*Internal Report: Traffic Regulation and Safety***Bessboro – The Farm and Bessboro – The Meadows SHDs - Traffic Regulation & Safety Report**

Internal Report: Drainage

Project:	Bessboro North “The Farm” Site SHD – Application
----------	--

Document:	Drainage Section Report & Conditions
-----------	--------------------------------------

Drawing file: Engineering Services / 21207-JBB-PH2-XX-DR-C-04009-Proposed SuDS Details.pdf

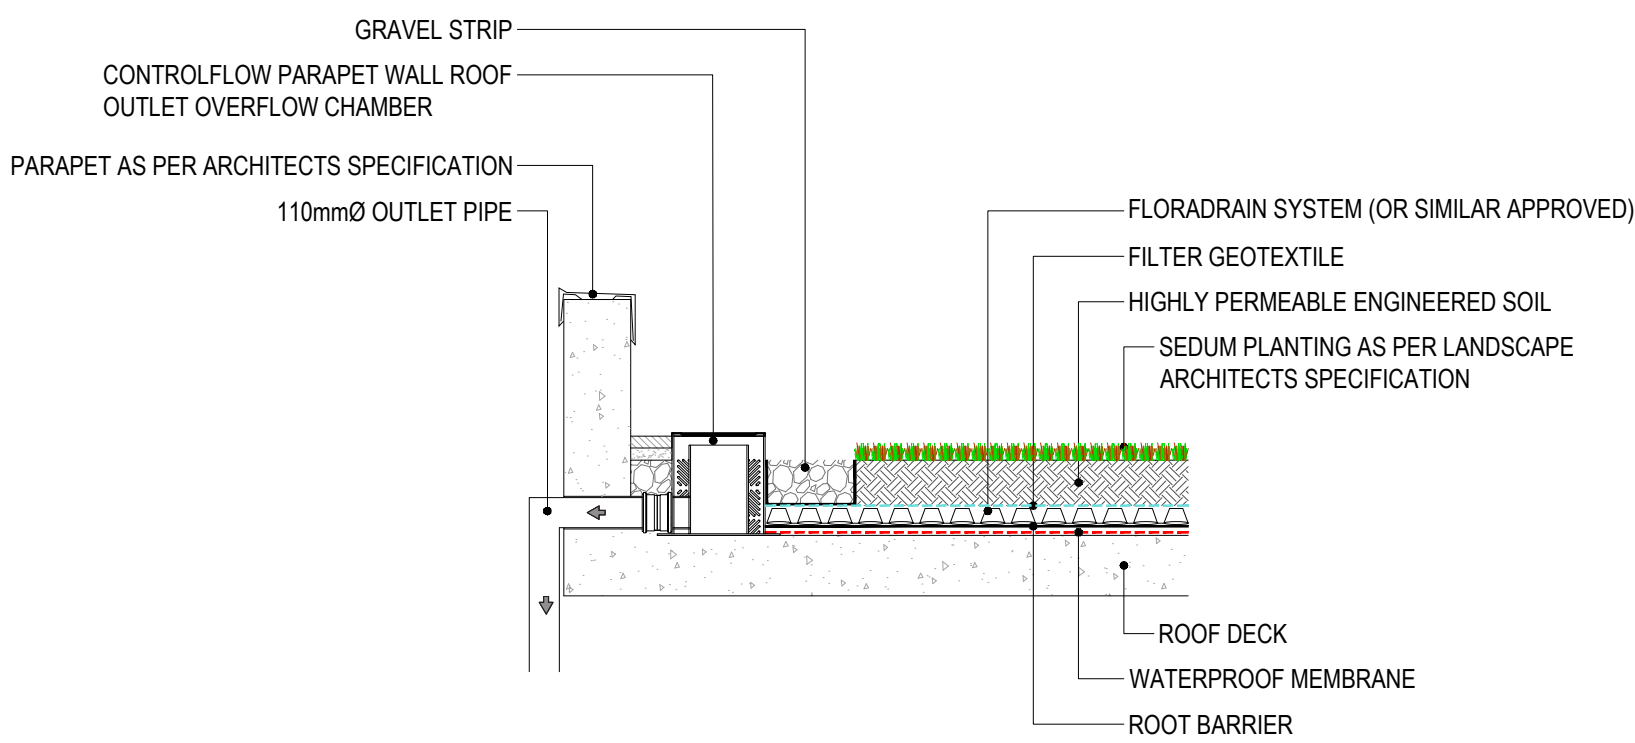
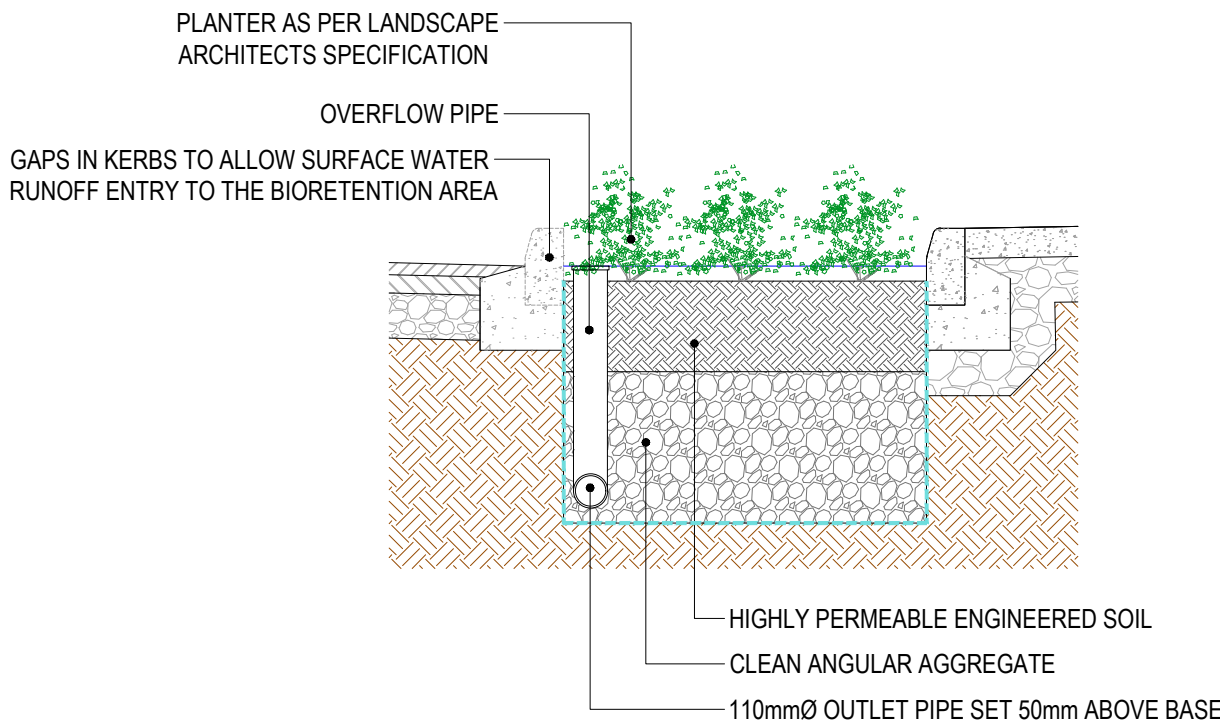
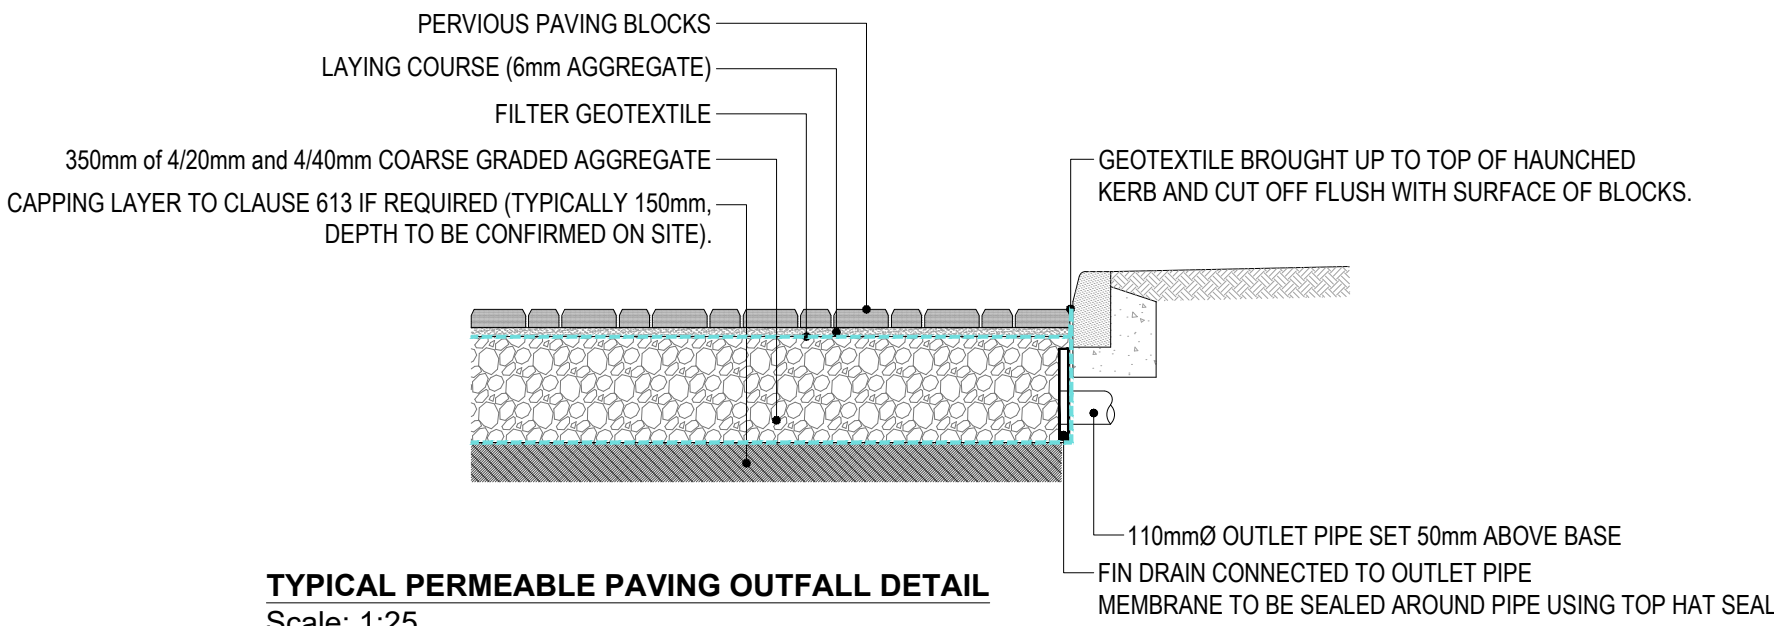
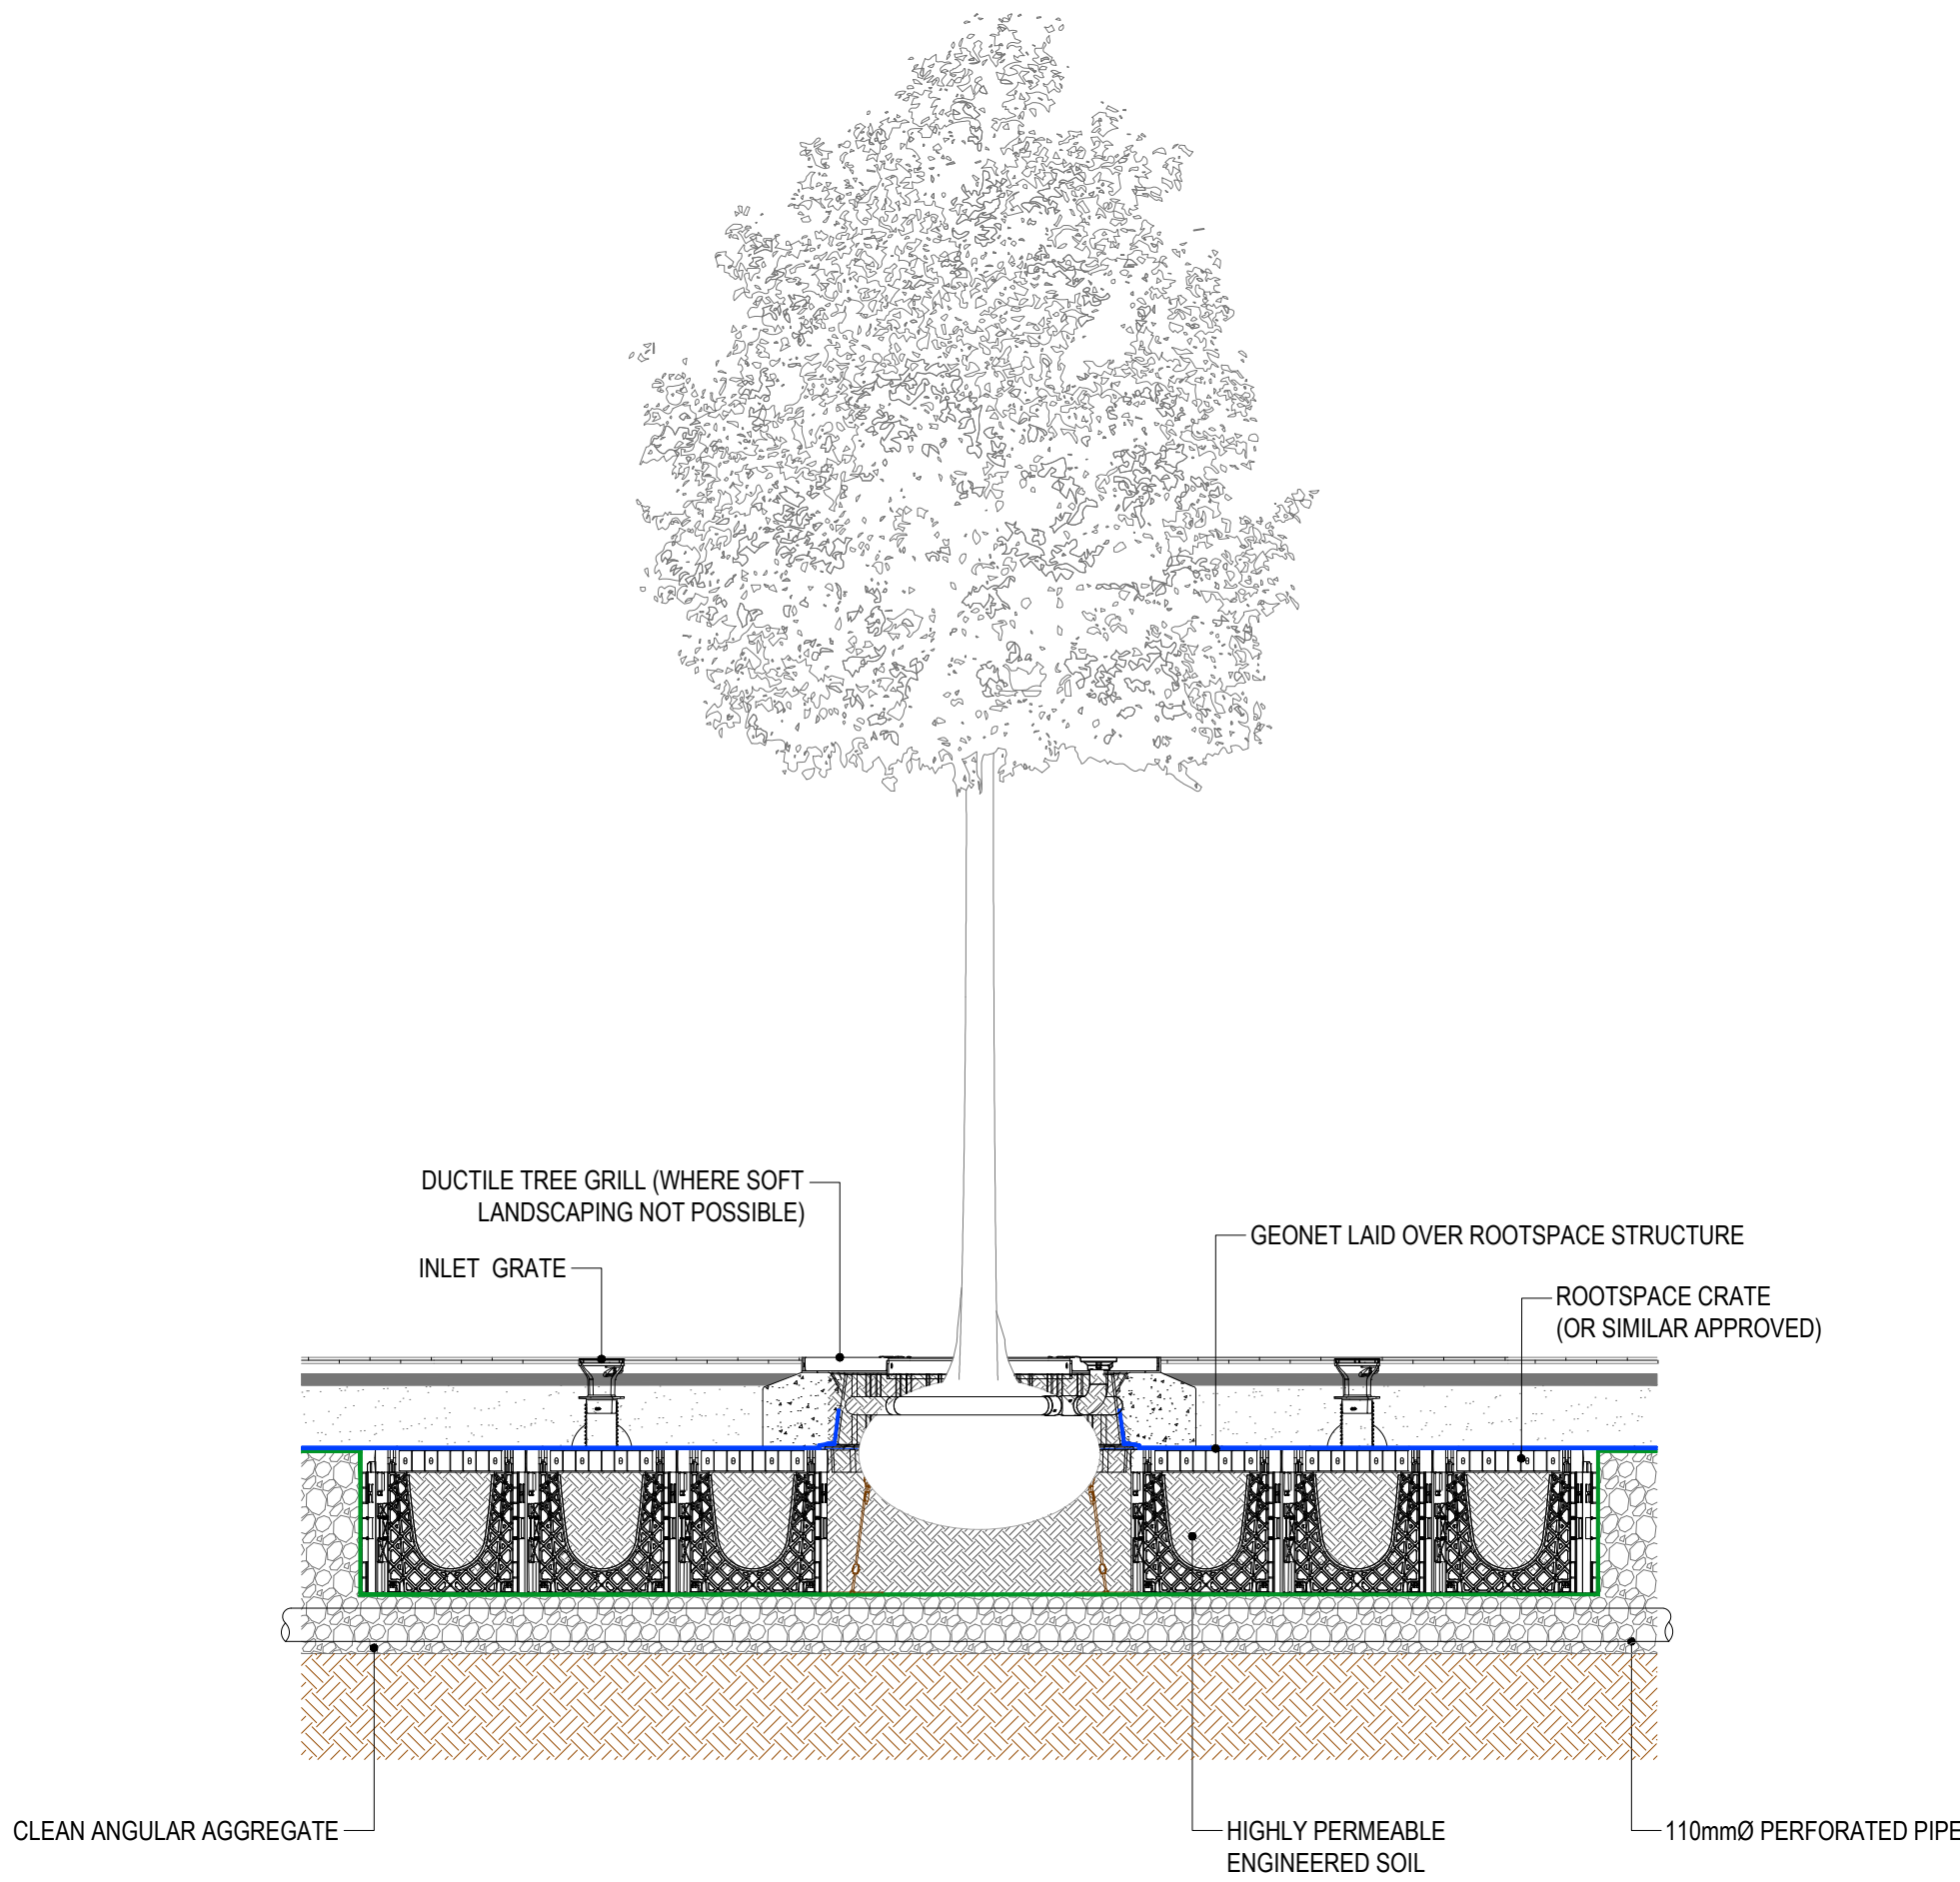
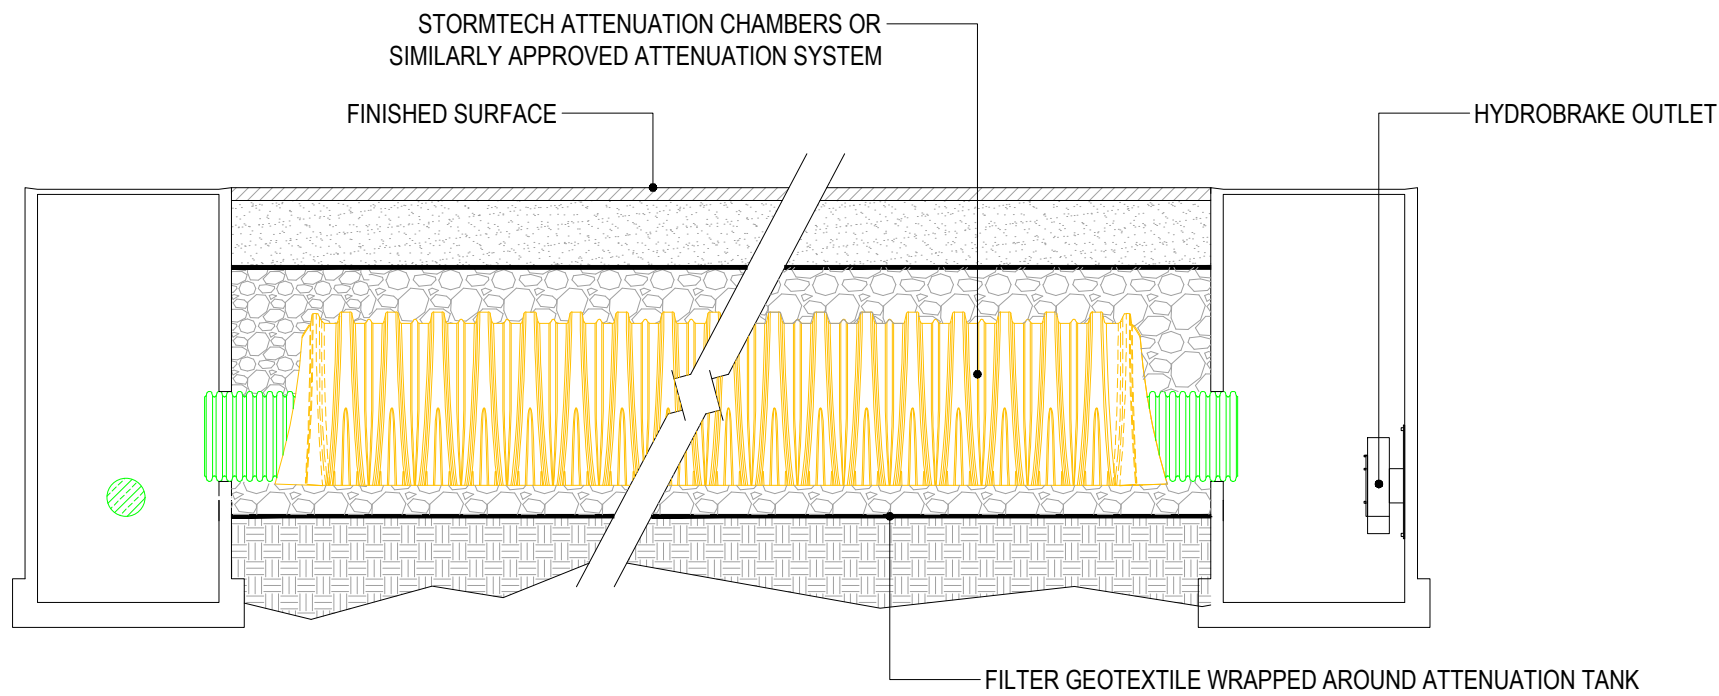
I would also encourage the Applicant to fully coordinate and integrate the proposed SuDS measures into the landscape strategy. For example, a revision to landscape master plan drawing IRLA-210604-2000, incorporating the details of the SuDS measures contained within JB Barry drawing 21207-JBB-PH2-XX-DR-C-04005, would be welcome.

A condition to be added.
